Subject: Re: A/76/15/PL Erection of single storey rear extension and remodelling of front car park area - Angmering Manor, High Street, Angmering

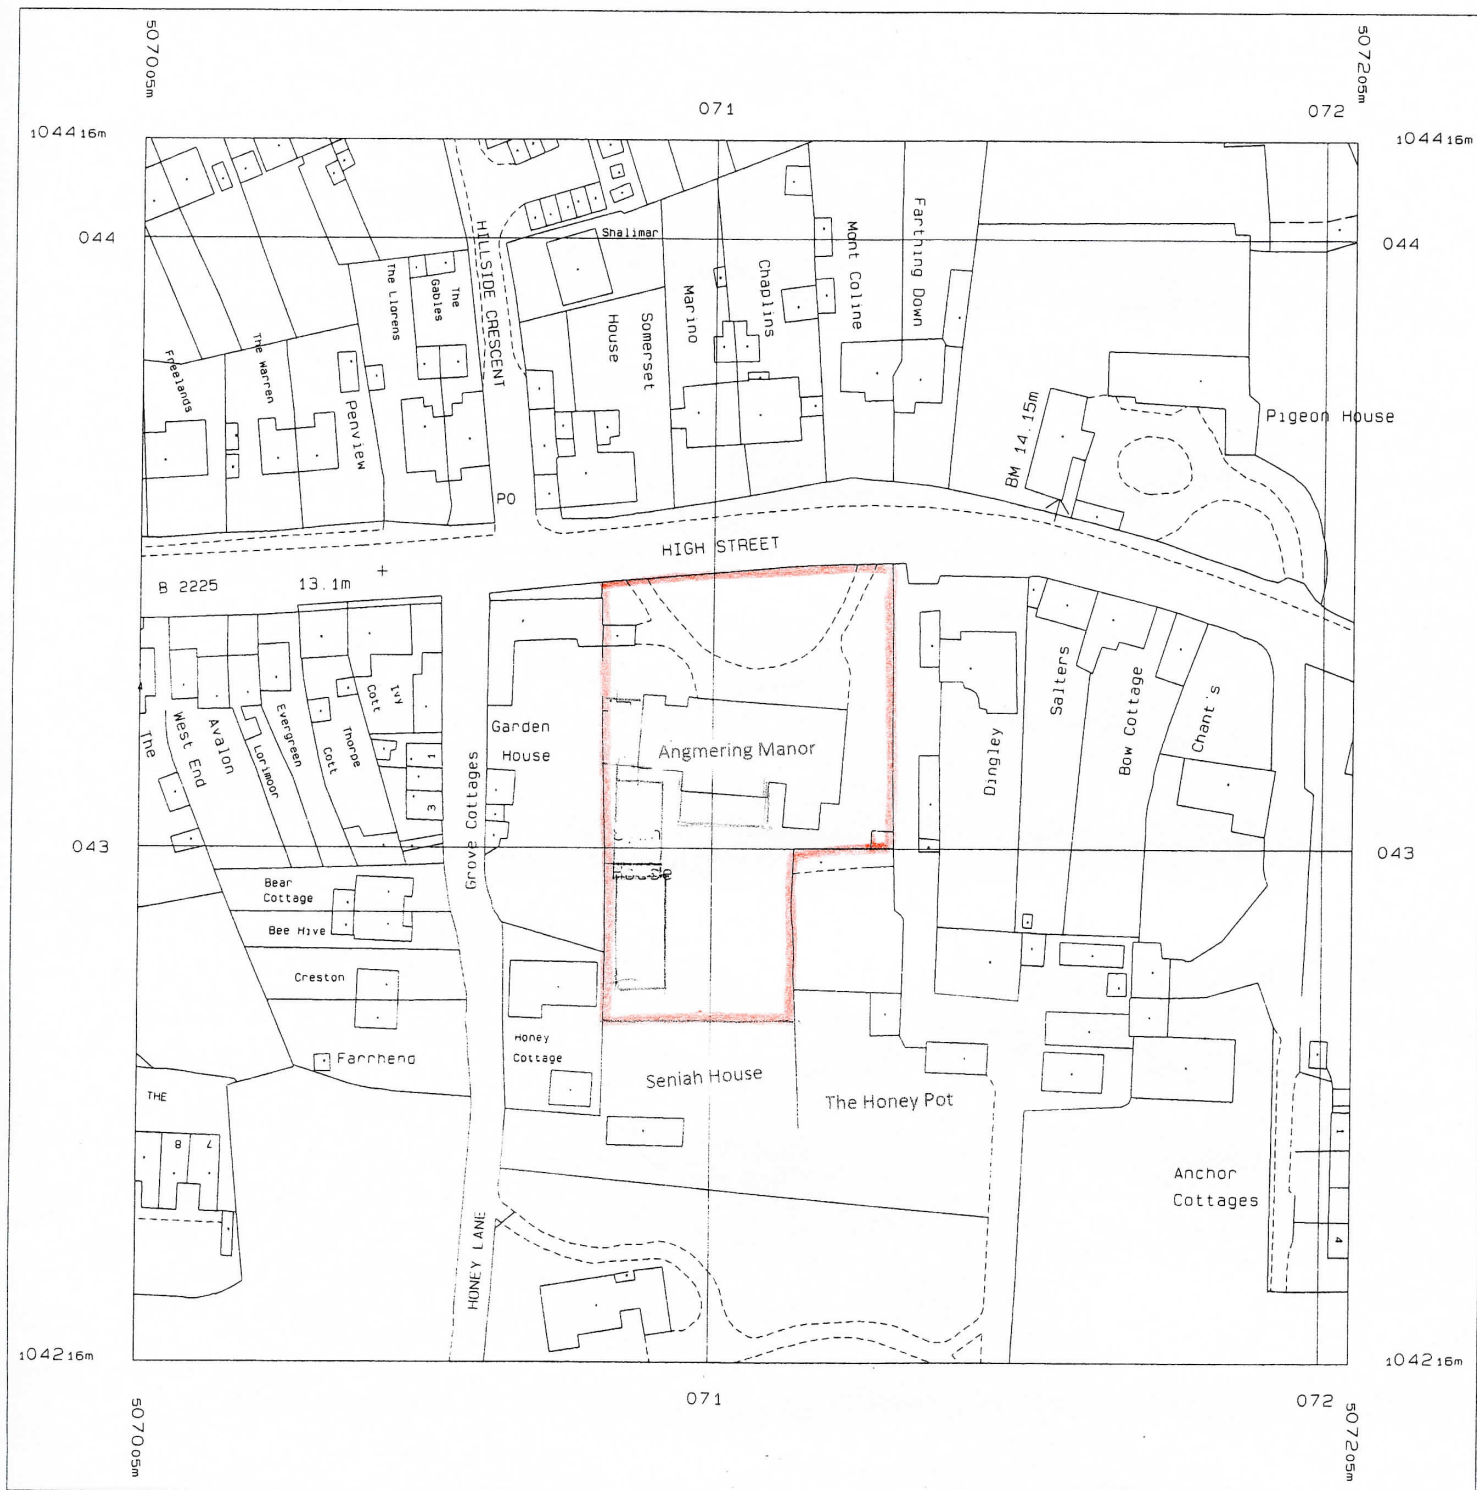
I have started looking at the above application in detail. Whilst I am still awaiting the comments of the Conservation Officer and Historic Building Adviser, without prejudice, I would appreciate receipt of a revised block plan, scale 1:500 to clearly indicate the position of the property to the rear Seniah House and dimension the distance to the rear boundary. The block plan shows a gap to the boundary of 5.65m. The ground floor plan indicates this distance as 5.45m and therefore clarification would be appreciated.

Further to your e-mail please find attached a further 1:500 scale block plan plotting the neighbouring property to the rear.

The correct dimension between the extension and the rear boundary is 5.45m and this is marked on the plan.
